Application: SSI 7485

I write regarding the proposed modification to M4-M5 Link, Mod 2 The Crescent overpass and changes to pedestrian infrastructure in North Annandale, Rozelle and Rozelle Bay Foreshore area.

Figure 4-2 Pedestrian and cyclist bridge infrastructure options

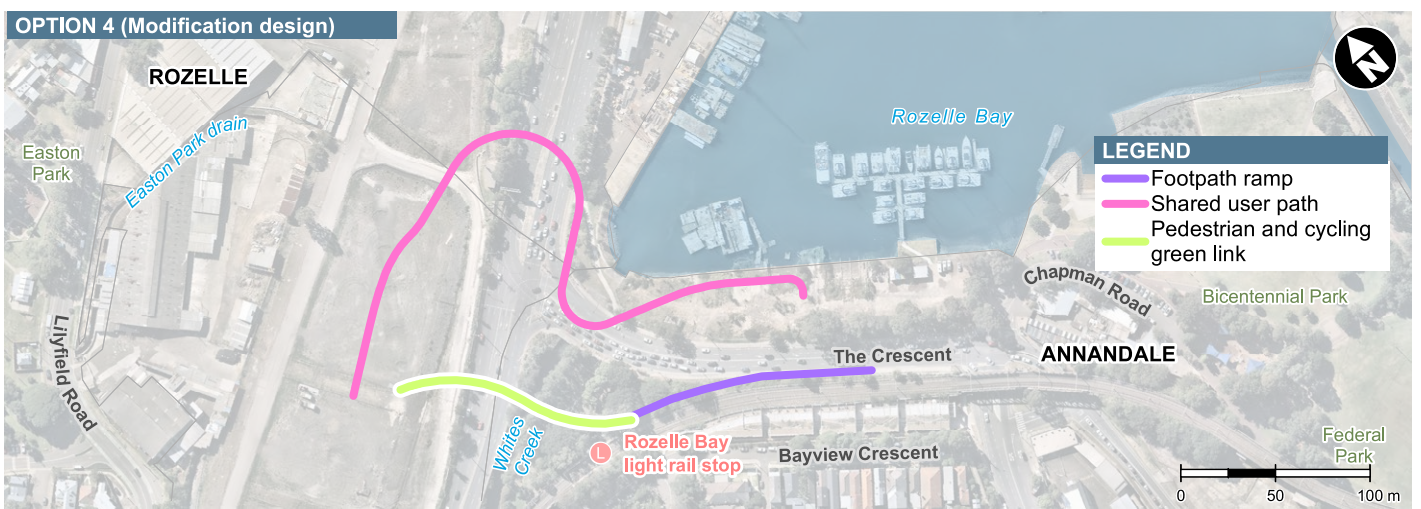
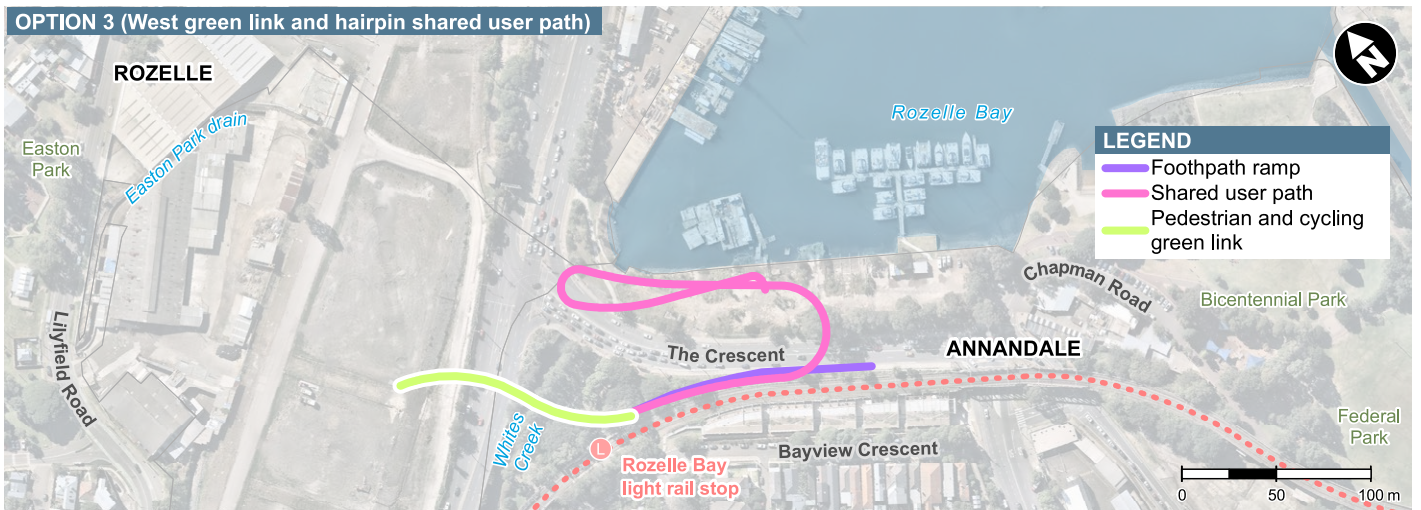
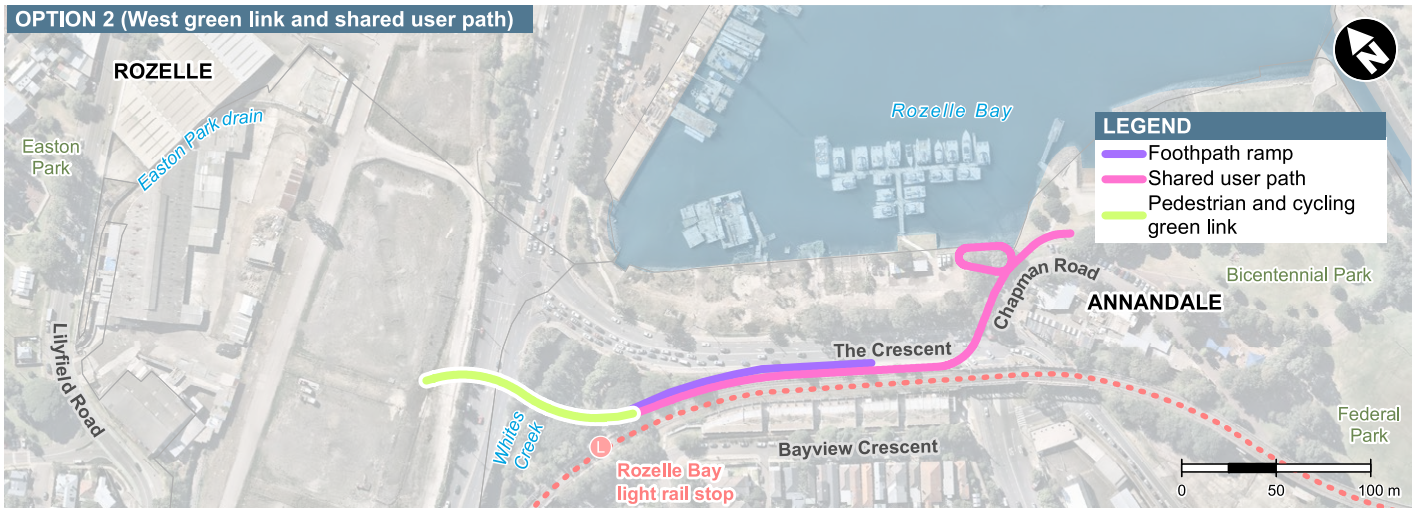
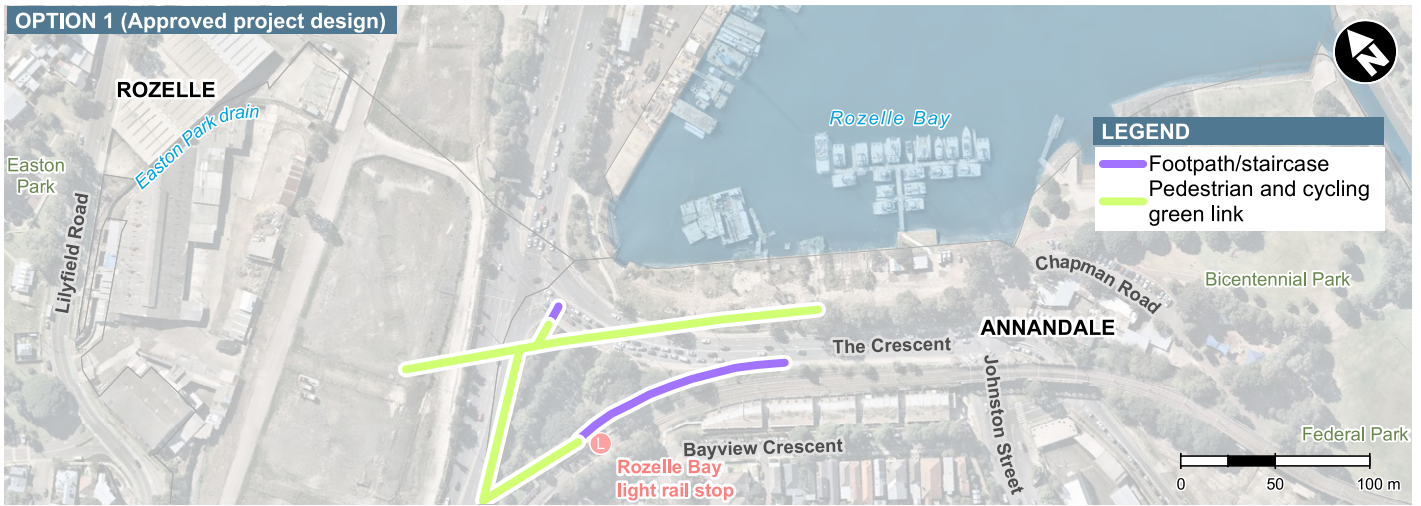
I request RMS work with the community to explore alternate design options to the proposed new car overpass design and the changed pedestrian and cyclist links. I am seeking the reinstatement of the safe, direct access from the approved EIS GreenLink to create a continuous green open space connection from the Rozelle Rail yards and Annandale to the foreshore. The GreenLink was more than just a walk way - it put people central to the design, maximising safety, and providing much needed accessible open space for the community now and into the future Bays Precinct design.

- The significantly reduced safety and increased risk for pedestrians and cyclists with removed access over The Crescent to Bicentennial Park and the increased traffic along Johnson Street.
- Being required to cross five sets of pedestrian lights at The Crescent as my option to reach the foreshore from Annandale or from Rozelle Bay light rail stop.
- Removal of direct active links to the foreshore, cutting the community off from the area and the proposed revitalisation of the entire Bays Precinct, including linking the Light Rail and Bus stops to a Ferry wharf and Metro station.
- Urban and landscape design that is being built before a finalised Masterplan for the area.
- Traffic changes that limit movements around the suburb and create further congestion in the local streets of Annandale, Forest Lodge, Glebe, Lilyfield and Rozelle with no planning to deal with these.

- Reinstate the GreenLink connecting communities and green open space from Rozelle to Bicentennial Park
- Relocate and design pedestrian and cyclist connections that are continuous, safe and direct.
- Design the modification infrastructure and active links in response to the character of the suburbs, the location of the foreshore and it's potential future development.
- Provide pedestrian and cyclist paths that maximise people safety and do not force them onto busier streets, unsafe concrete plazas and caged walkways.
- Integrate active and direct connections to all active transport – including the future Metro West and Foreshore Ferry Wharf

• that at a very minimum ~~minimum~~ need date the original redemption & cyclist connections from Lilyfield to the Crescent & from Annandale to the foreshore.

Figure 4-3 The Crescent, Johnston Street, Chapman Road intersection options

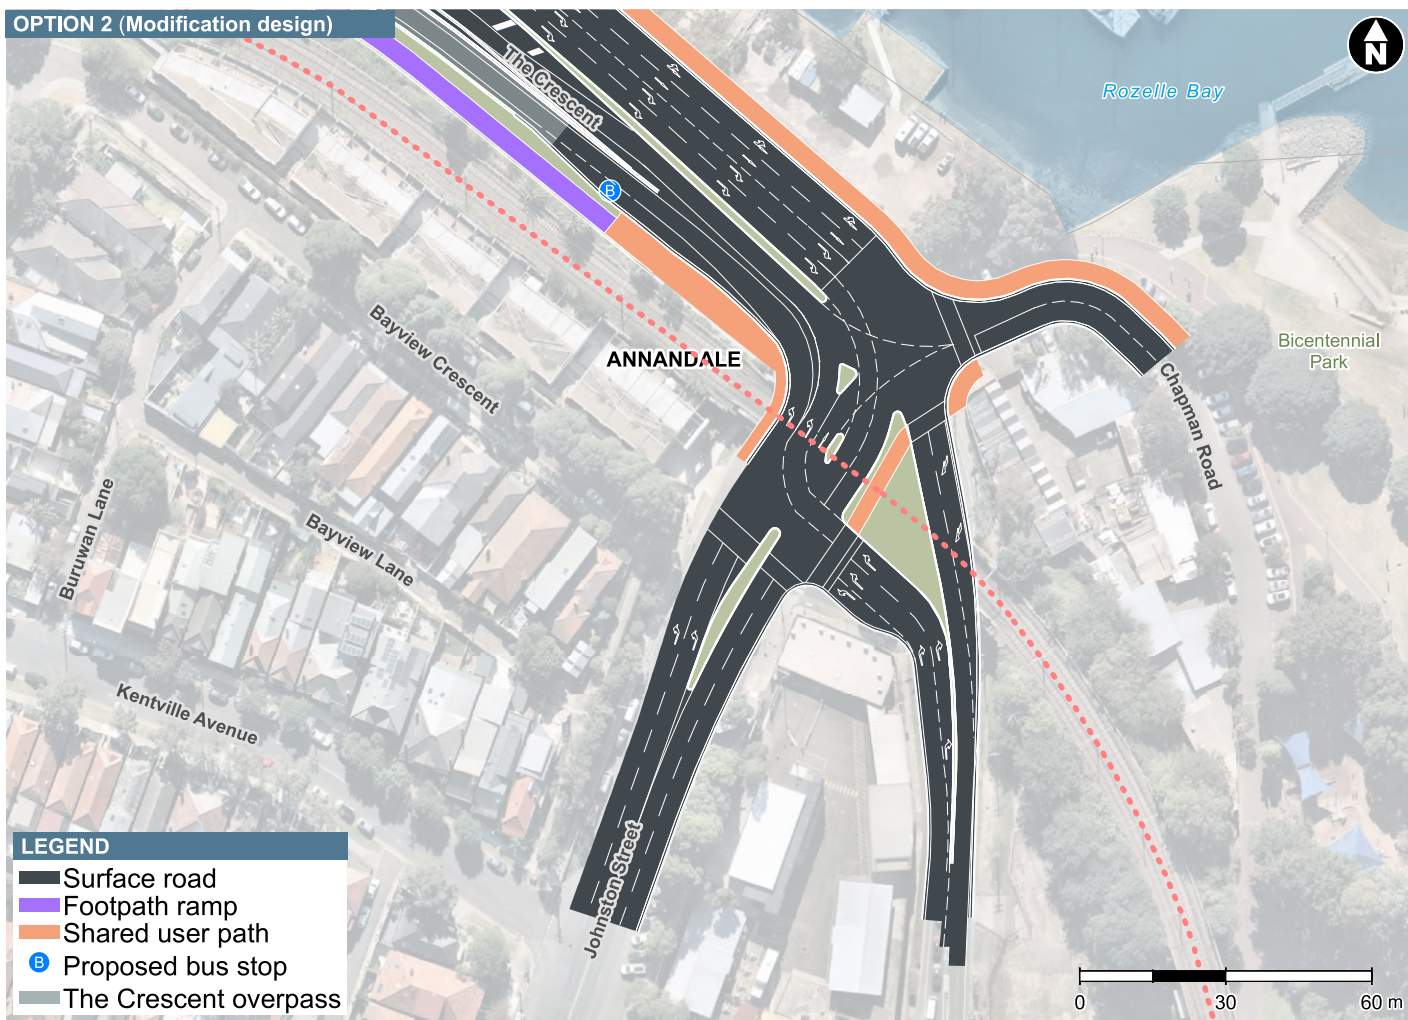
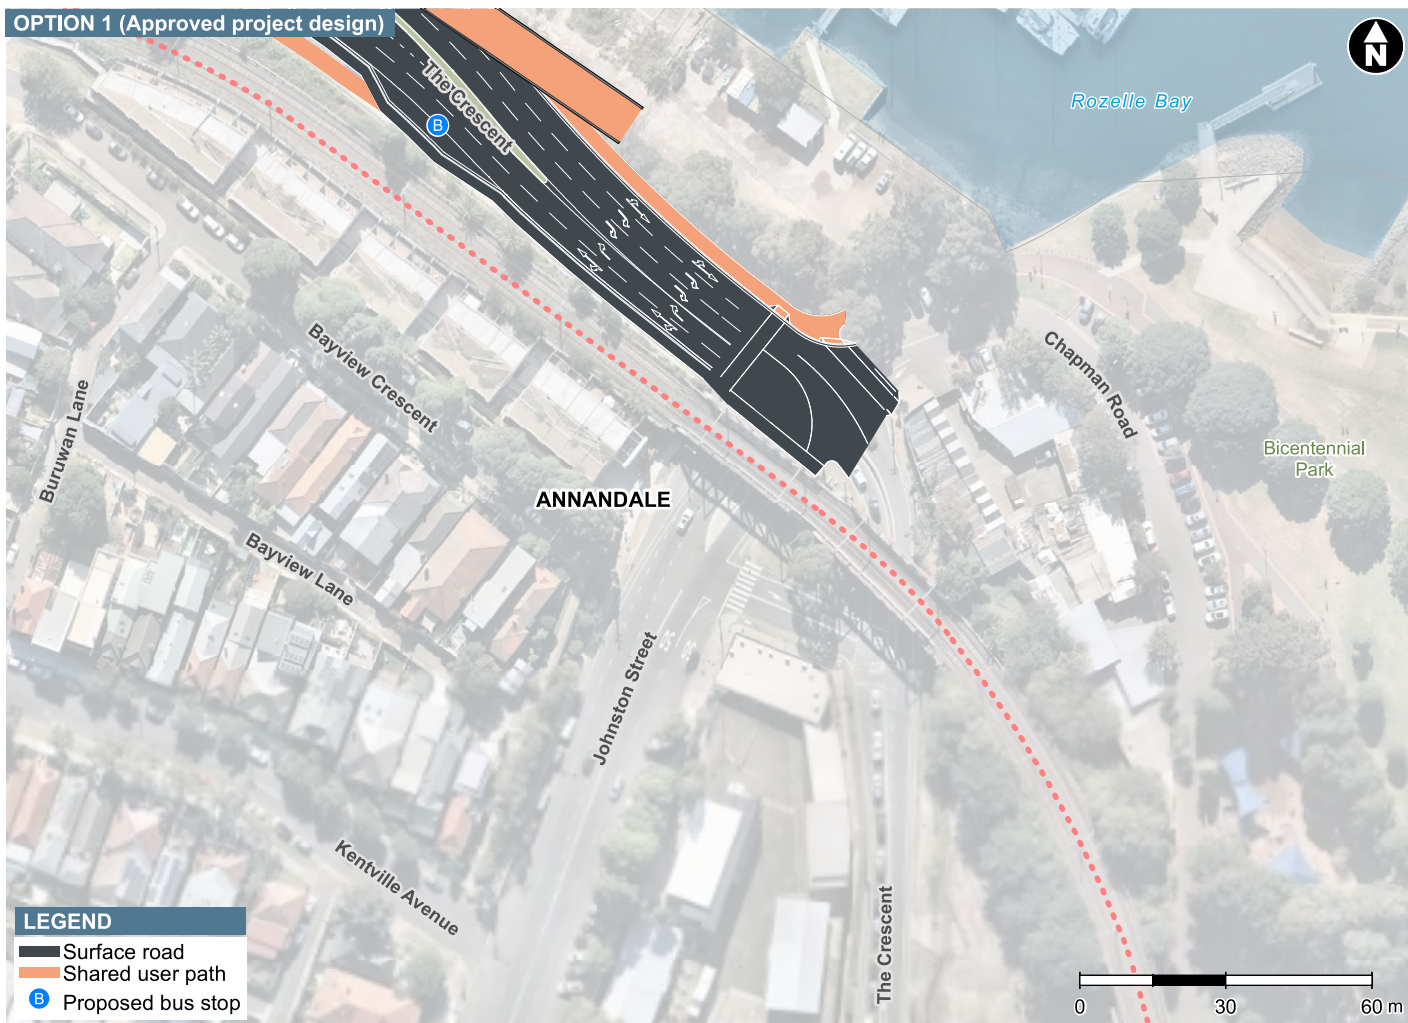
- No right turn from Johnston St. to the Crescent
- very late change to the previously agreed plan
- no consultation on the new, changed plan with it being presented as a fait accompli because it seems from the work being undertaken in the old rail yards that the new plan is already underway.
